RE: 133 YORK STREET

We are working on responses to the Staff's comments. Noting your deadline to prepare the staff memo, here is a partial response to help resolve some issues.

C1.1

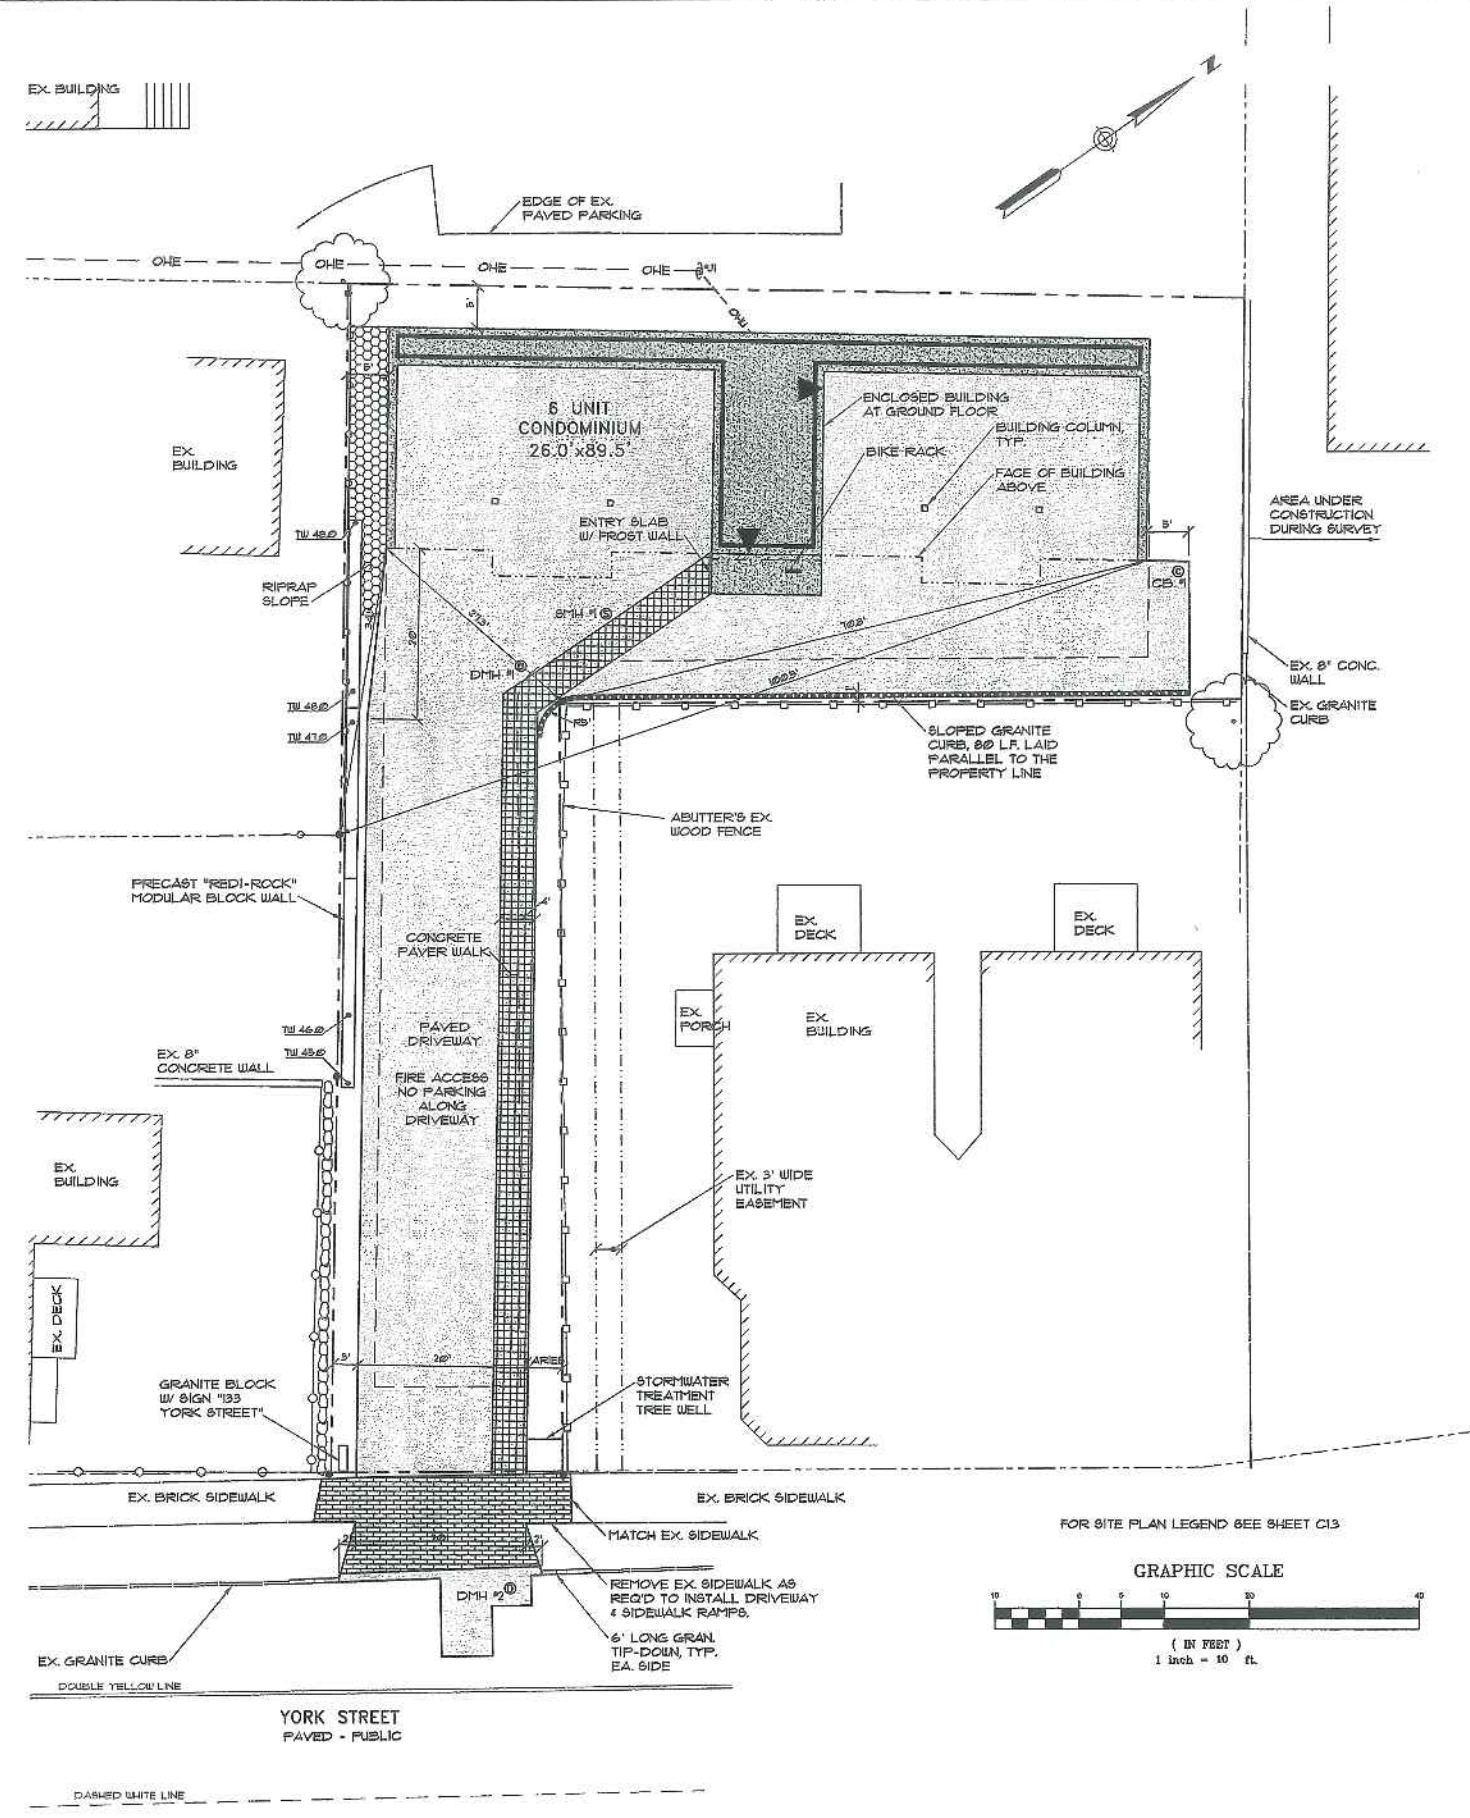
1. Tom Enrico noted a walkway to the front door would be helpful. We will provide a 4' wide path of concrete pavers from York Street to the door. These will be flush with the pavement to allow fire truck access over the full 20 feet of width.

TREE FILTER
 GENERAL DESIGN
 CONSTRUCTION DETAILS
 AND SPECIFICATIONS

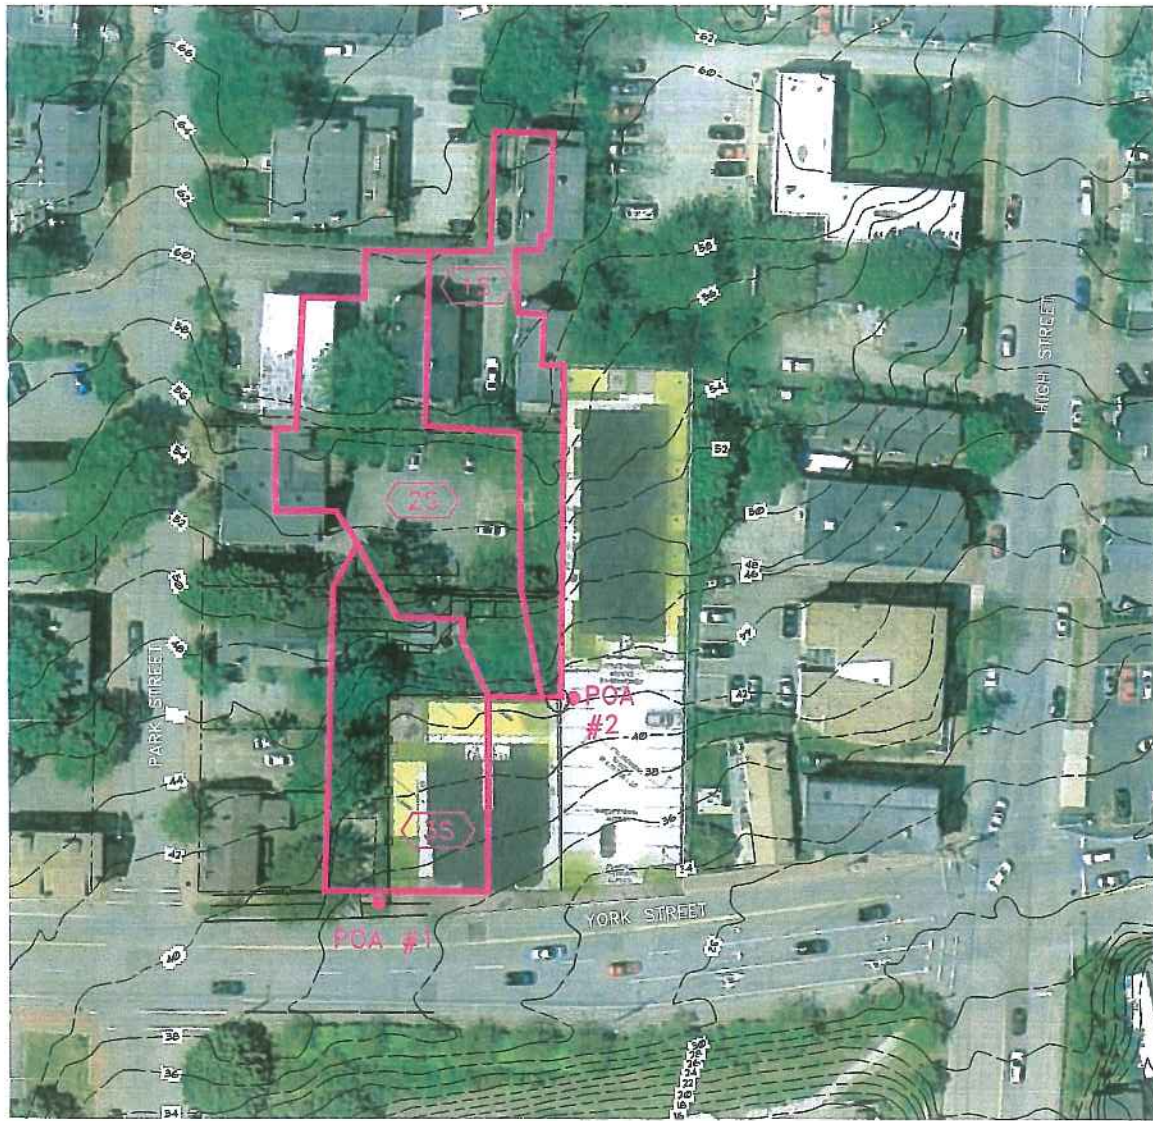
2. David Senus' comments.
 - 1.a We will provide mesh over the swale to the tree filter.
 - 1.b. Attached is the proposal from Green Street Filter Systems. Final design of the system will be submitted as part of the construction process.
